A47 Dualling – Blofield to North Burlingham

On behalf of Lingwood and Burlingham Parish Council.

Response to Highways England's Deadline Submission 2 - WCHR Assessment and Review Revised July 2021. TR010040-000466/EXAM/9.8

Figure 2-5: Route of Burlingham FP1

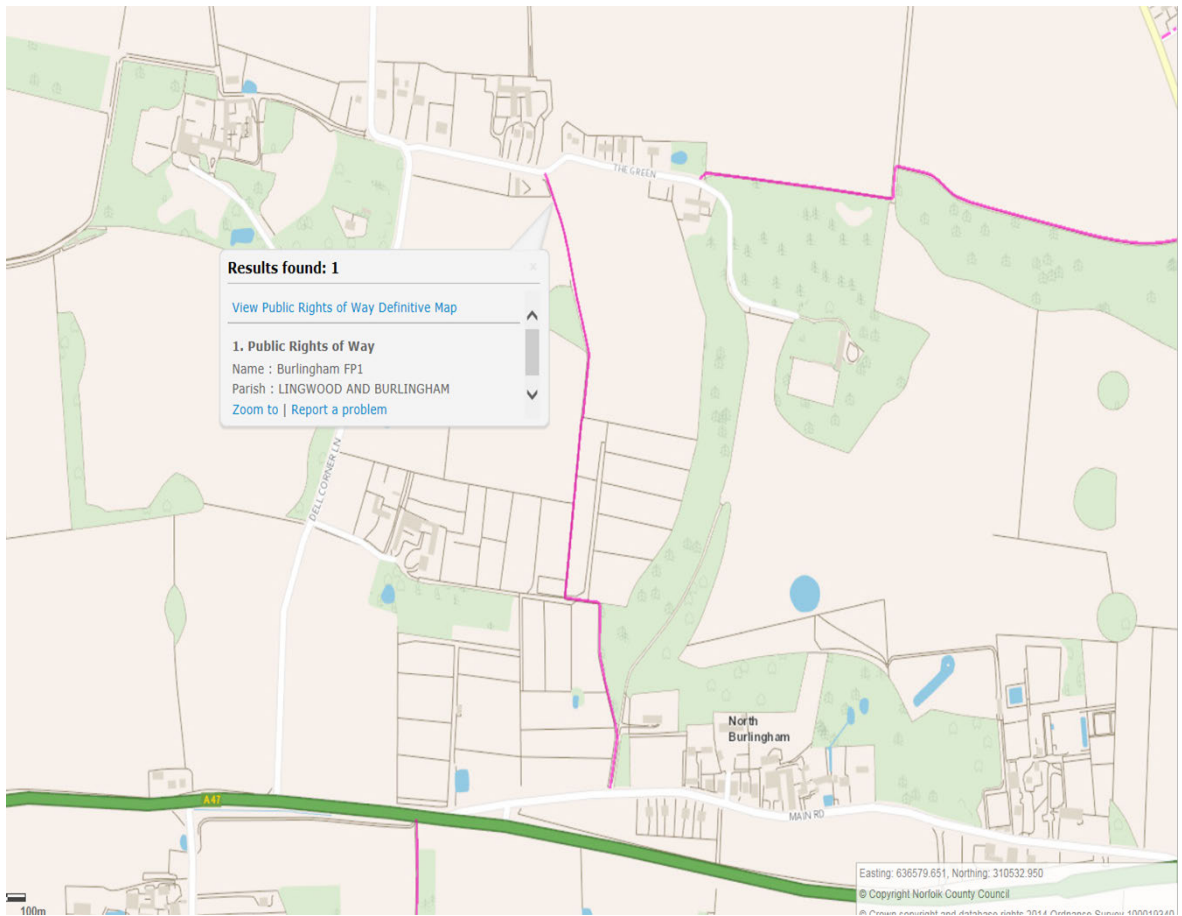
Clause 2.9.11 - "*The surveys recorded high usage of Burlingham FP1, which runs north to south from Main Road to the north of North Burlingham, A maximum two-way flow over the 12hr survey period of around 70 users was observed on a weekday whereas the maximum flow on a Sunday was around 90 users.*"

There is a car park at the start of FP1 which would account for the high usage. If some of the people using FP1 had been asked where they had travelled from, Highways England would have learnt that many people from Lingwood like to walk in Burlingham Woods, but we are forced to drive to North Burlingham because we cannot cross our parish on foot!

Figure 2-7: Route of Burlingham FP3

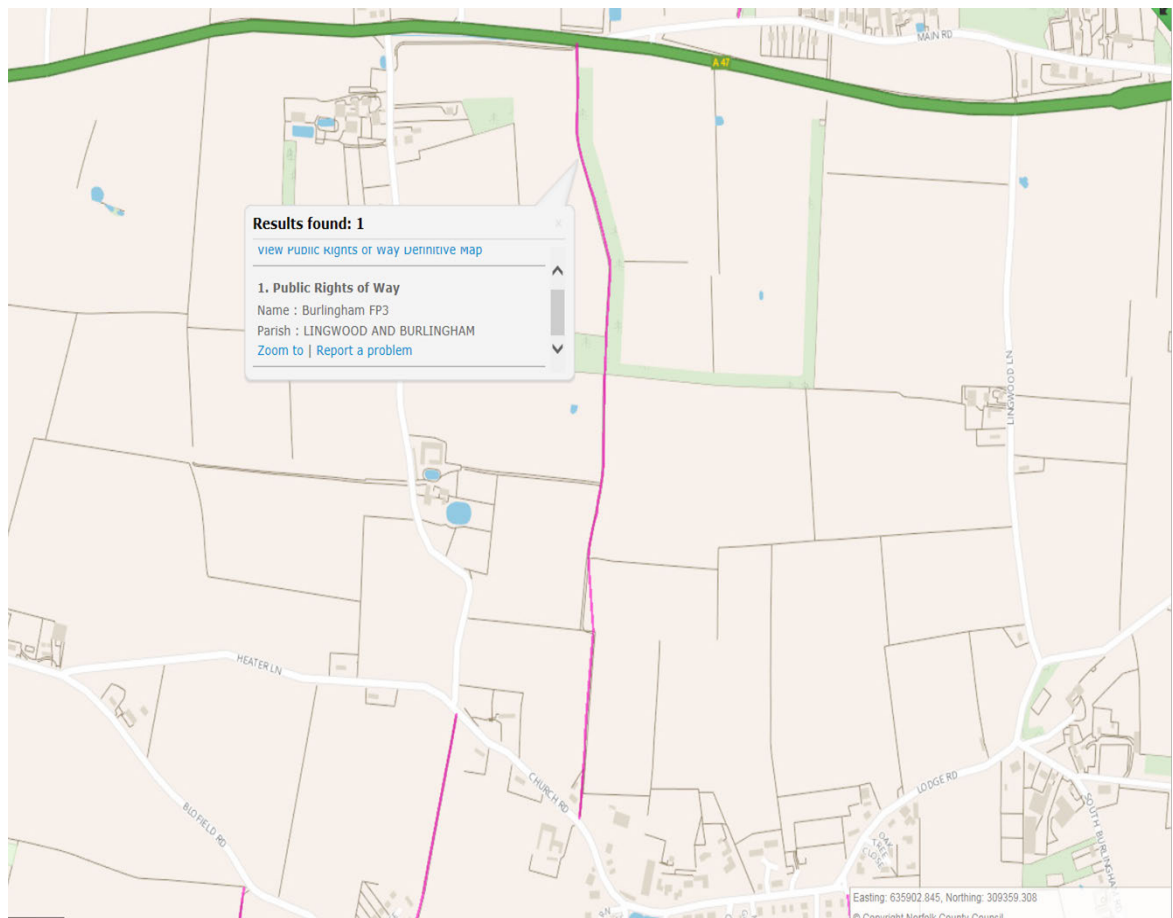
Clause 2.9.7 - "*During the Sunday survey periods, a maximum two-way flow of 10 users was recorded using Burlingham FP3, the majority of which crossed the A47.*"

Highways England recorded several other people crossing the A47 at other points and other times, which proves pedestrians and cyclists do need to cross the road. Most local walkers and cyclists would not try.

Highways England has ignored a petition signed by over 1,000 people who say they would use an underpass or footbridge if there was one. Also, it would appear Highways England has ignored previous submissions and remarks made to the Inspector by Lingwood and Burlingham Parish Council, by individual walkers and cyclists, and by various interested organisations.

A detour from the point where FP3 meets the A47 to the corresponding point north of the A47 using the proposed overbridge at the B1140 is approximately 2 miles. (Desk-based exercise.) How many pedestrians would (or could) add this distance to their walk through the woods?

**HE551490-GTY-HKF-000-DR-CH-30006**

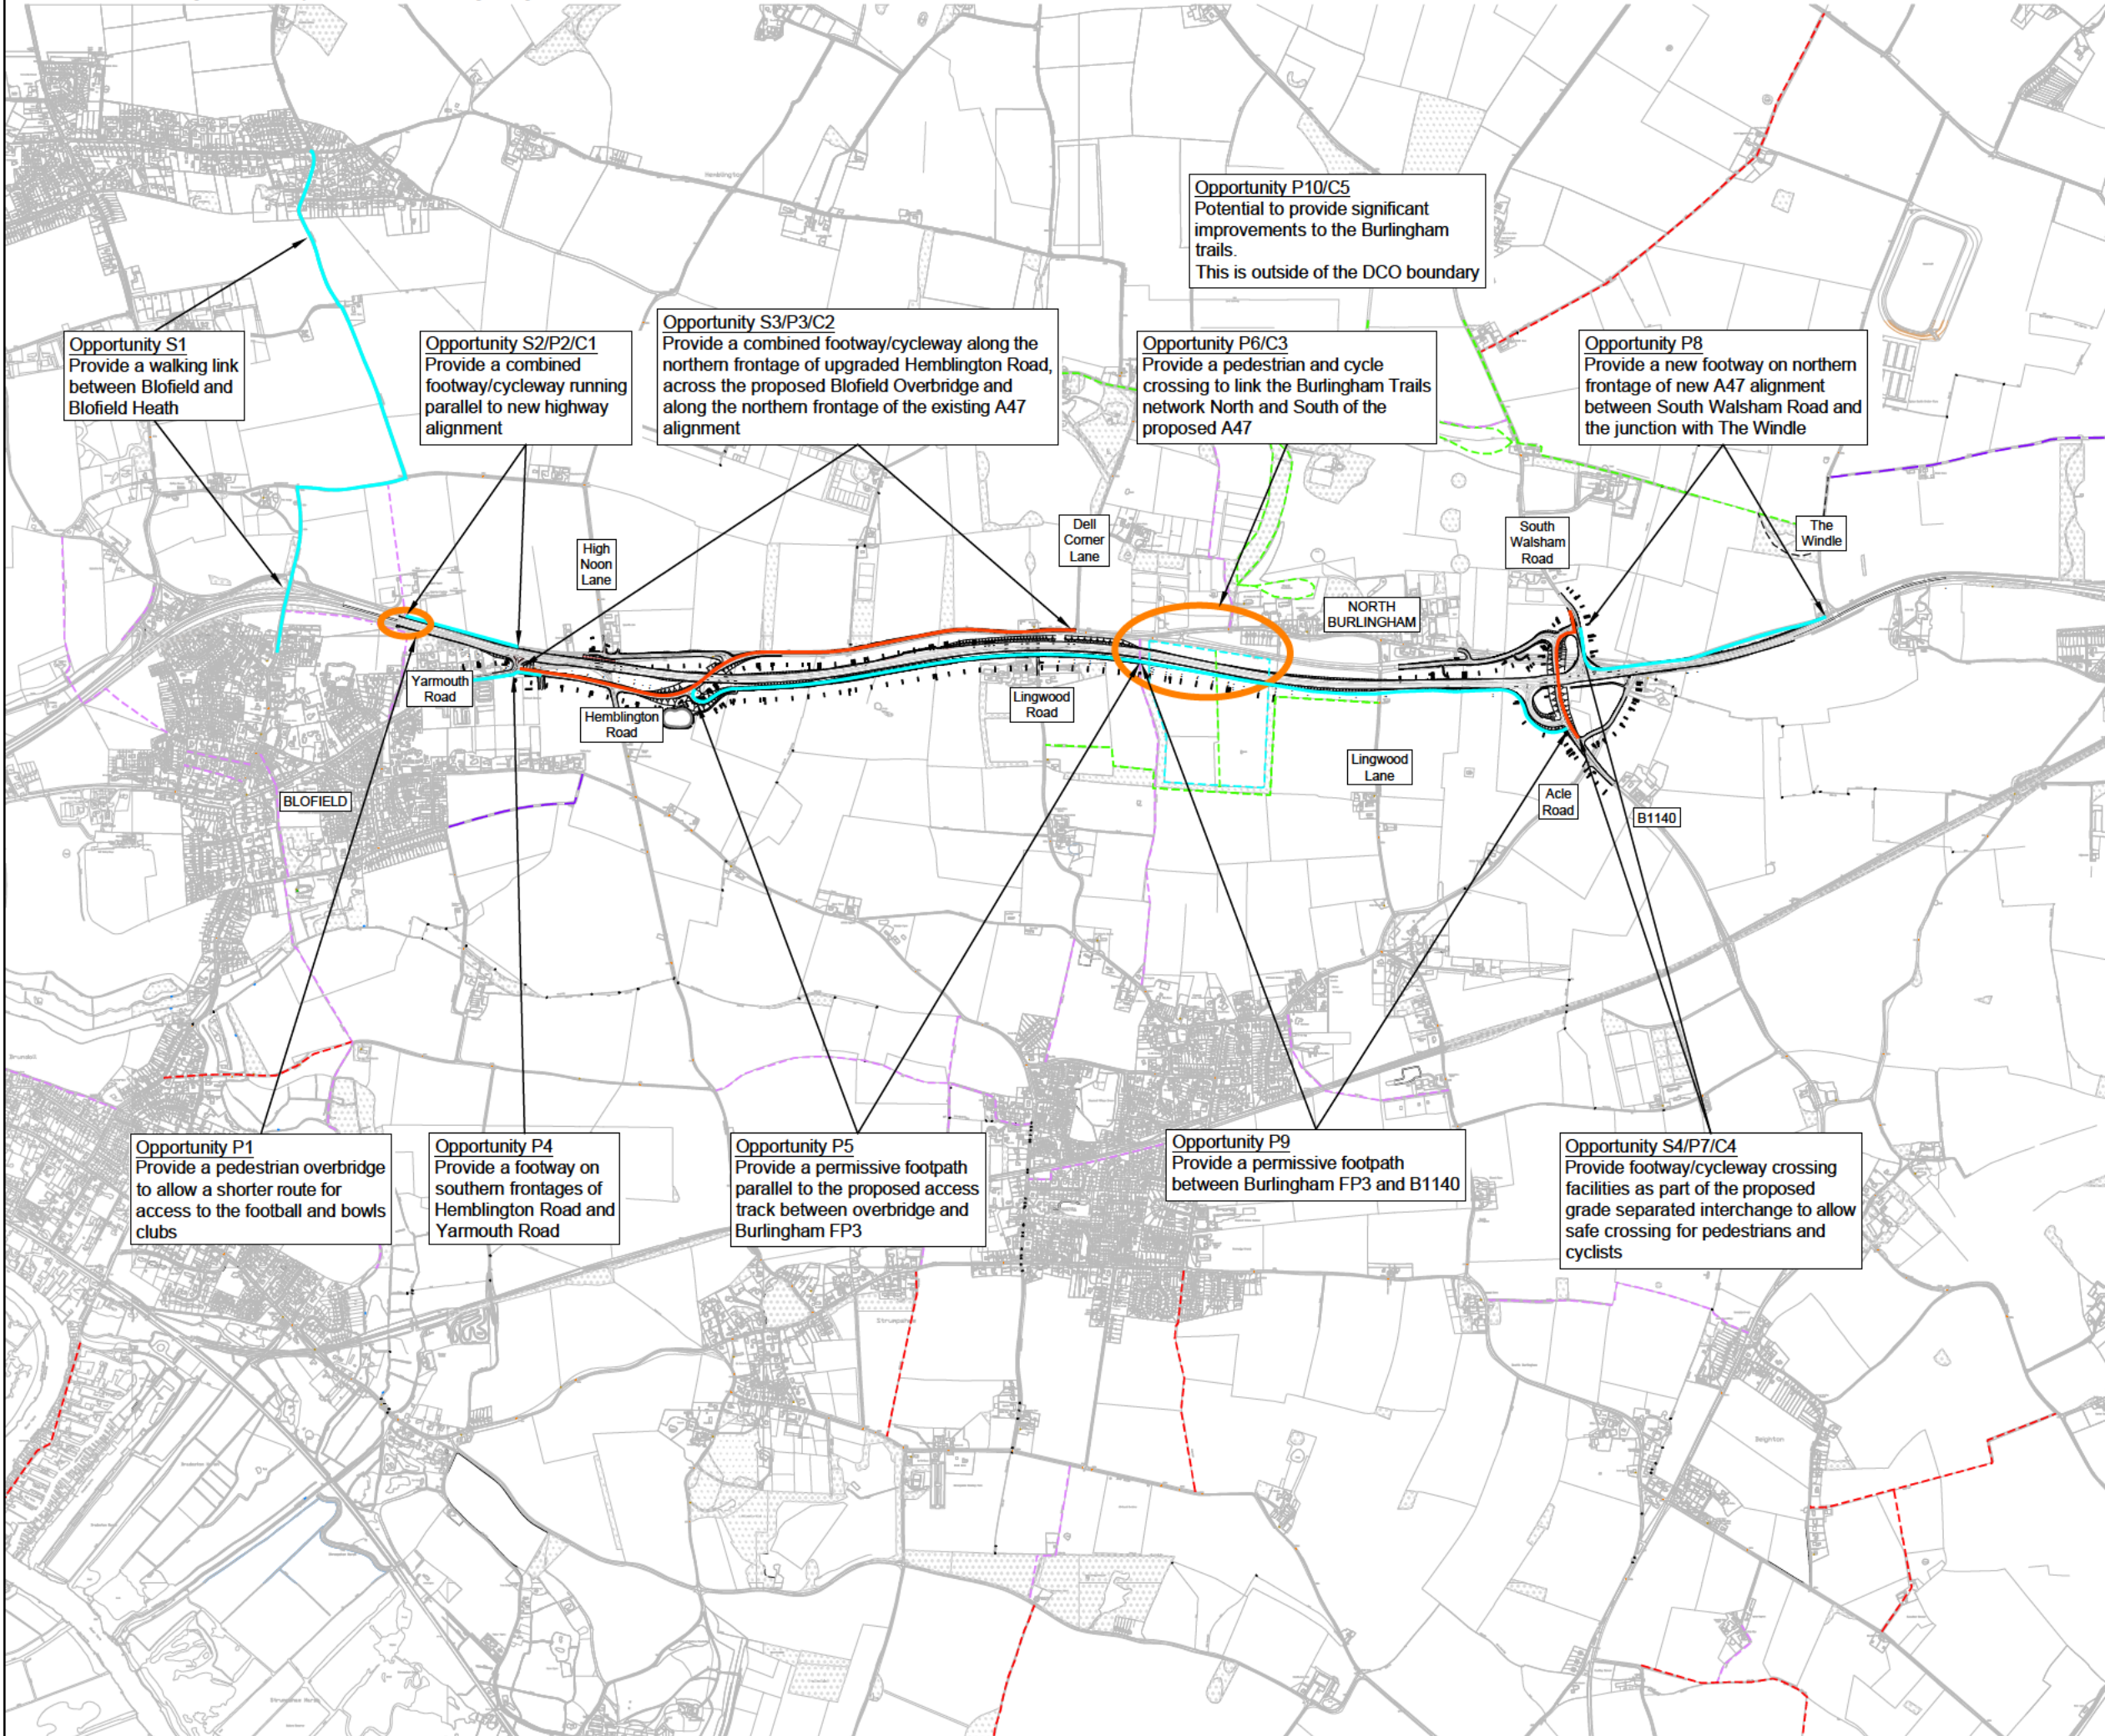
Clause 2.5.2 Appendix A: WCH facilities and local amenities. (Assumed should read WCHR.) This clause states, '*It can be seen from the drawing that the majority of the local amenities are located within Blofield*'.

Acle has been cut off this map by Highways England and no amenities or facilities in Acle are highlighted. Why not?

DRAWING NUMBER  
**HE551490-GTY-EPC-000-DR-LX-30001**

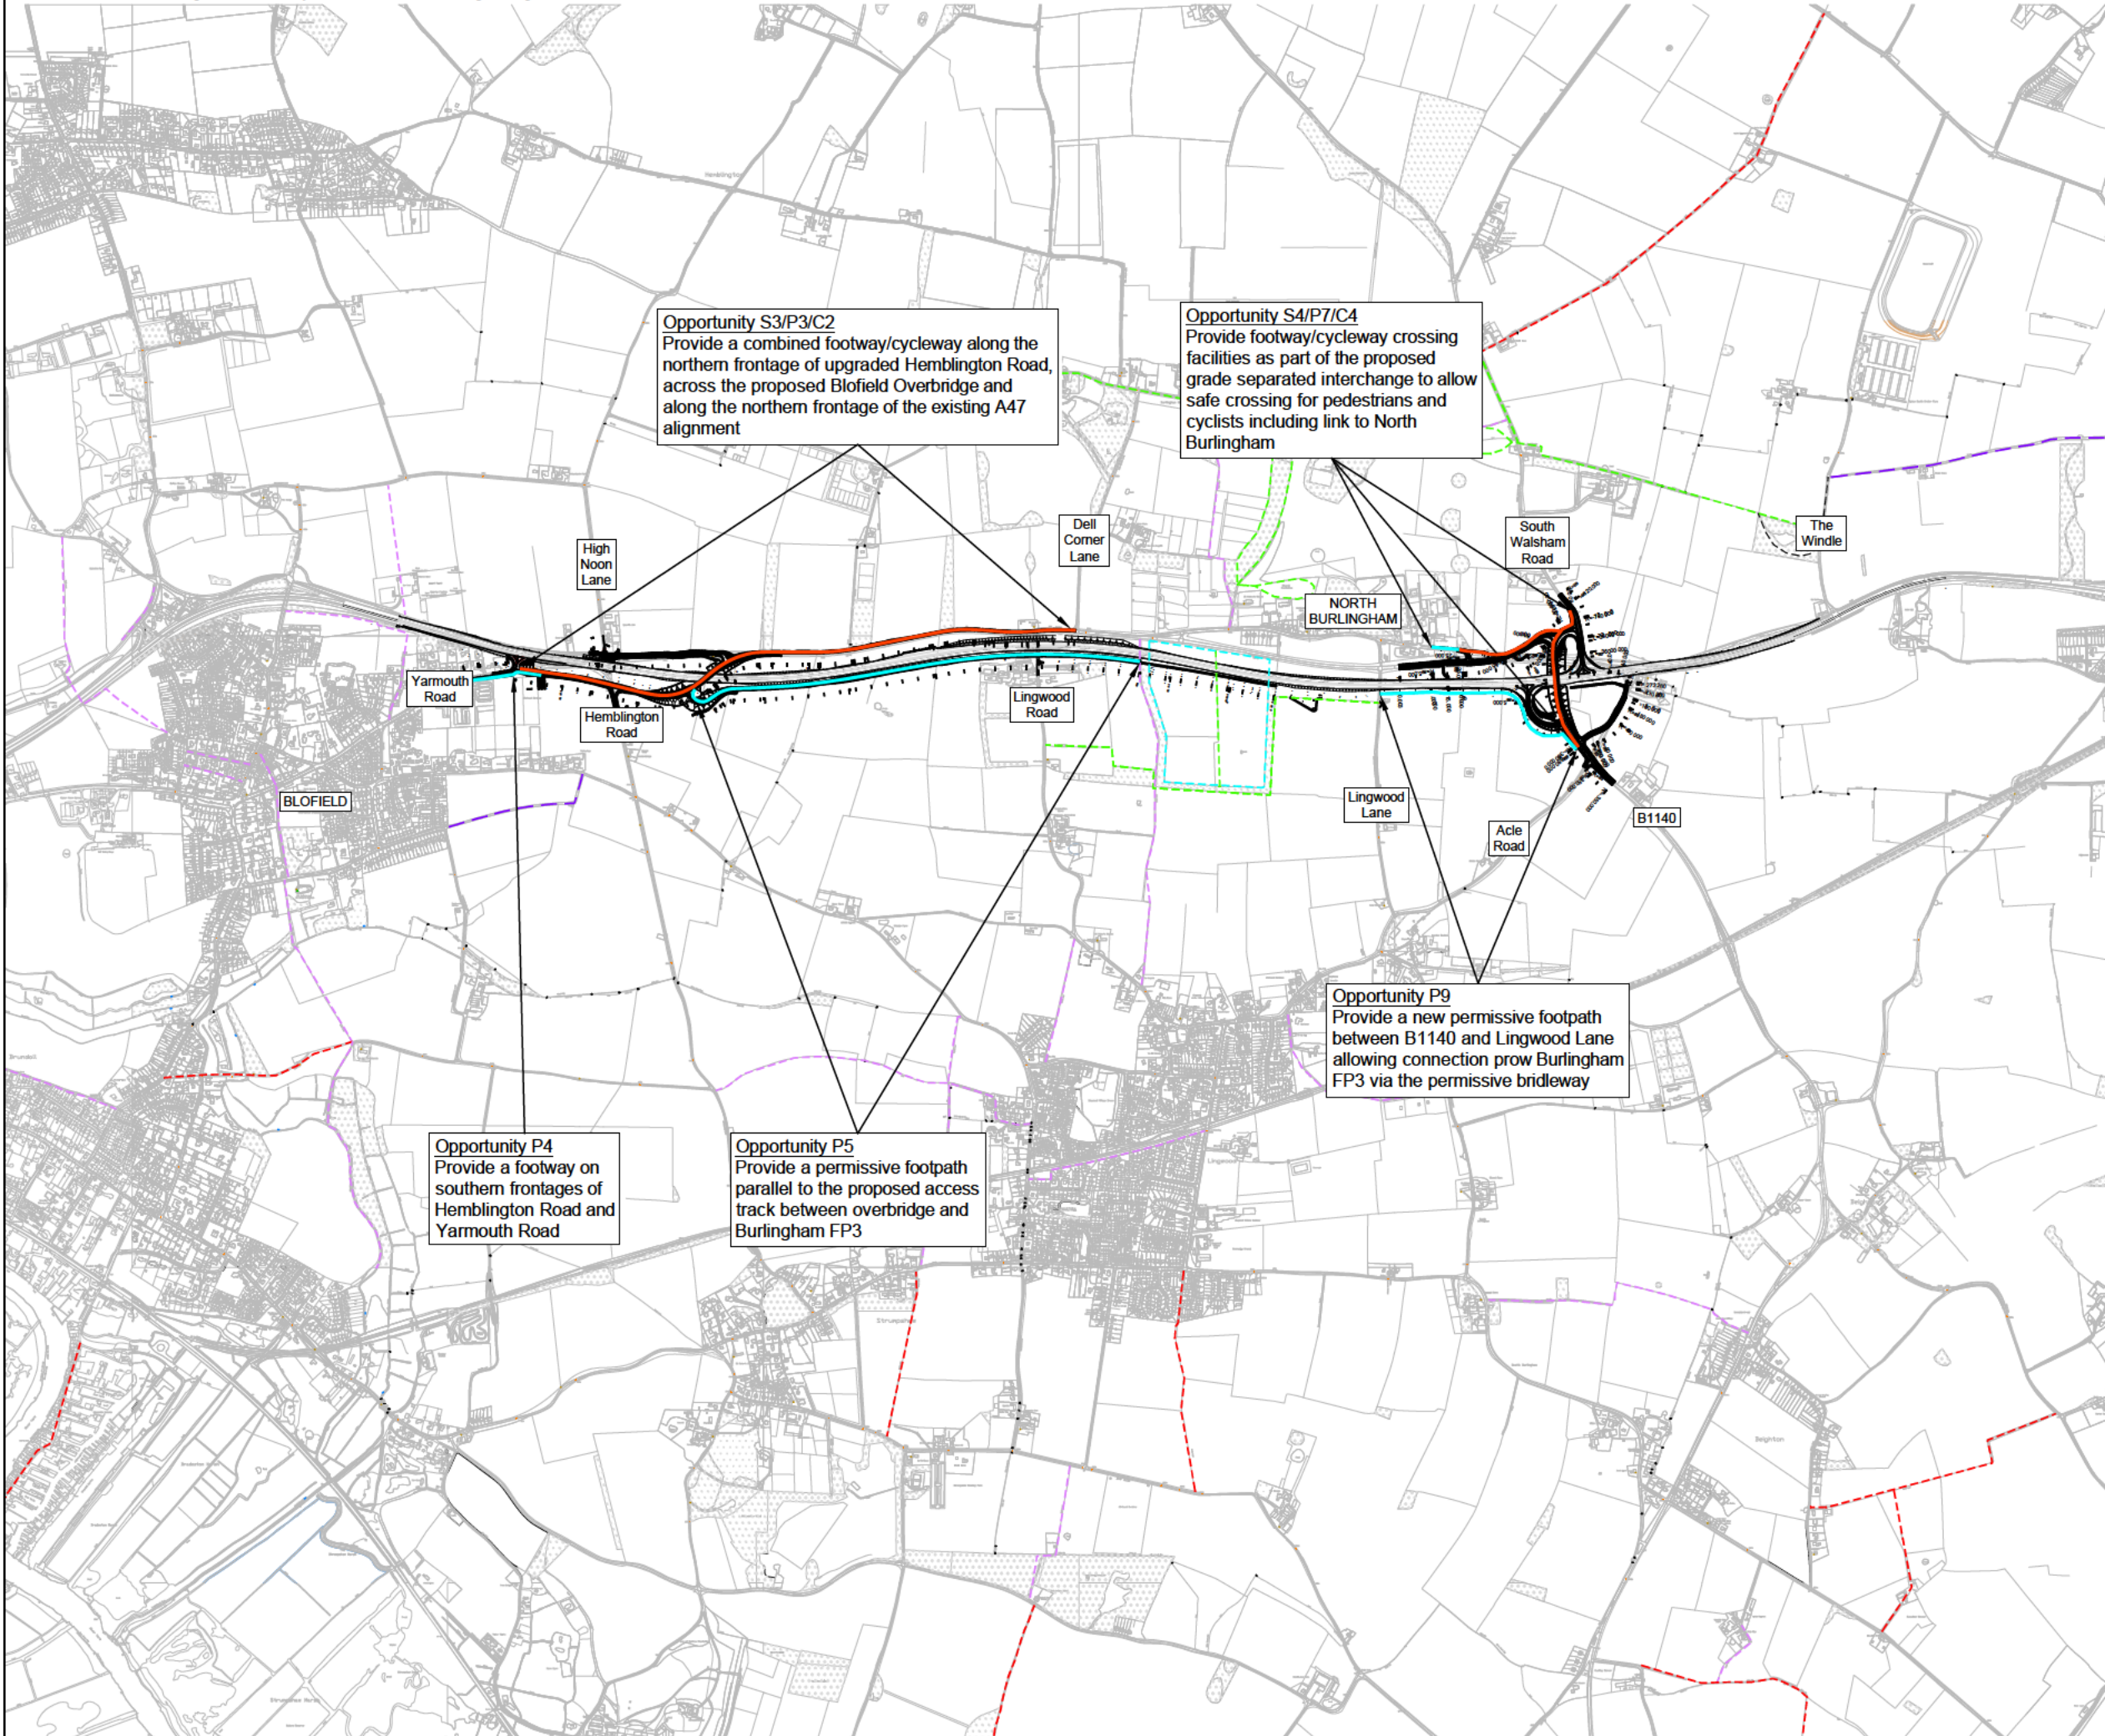
Opportunity P6/C3 - “*Provide a pedestrian and cycle crossing to link the Burlingham Trails network north and south of the proposed A47*”

Opportunity P8 - “*Provide a new footway on the northern frontage of the new A47 alignment between South Walsham Road and the junction with The Windle*”.

The Revised Assessment does not include decisions made concerning these opportunities but attaches another Appendix, the previous WCHR Review dated 11th August, 2020. That document makes it clear Highways England will not fulfil opportunities P6/C3 and P8.

Why not?
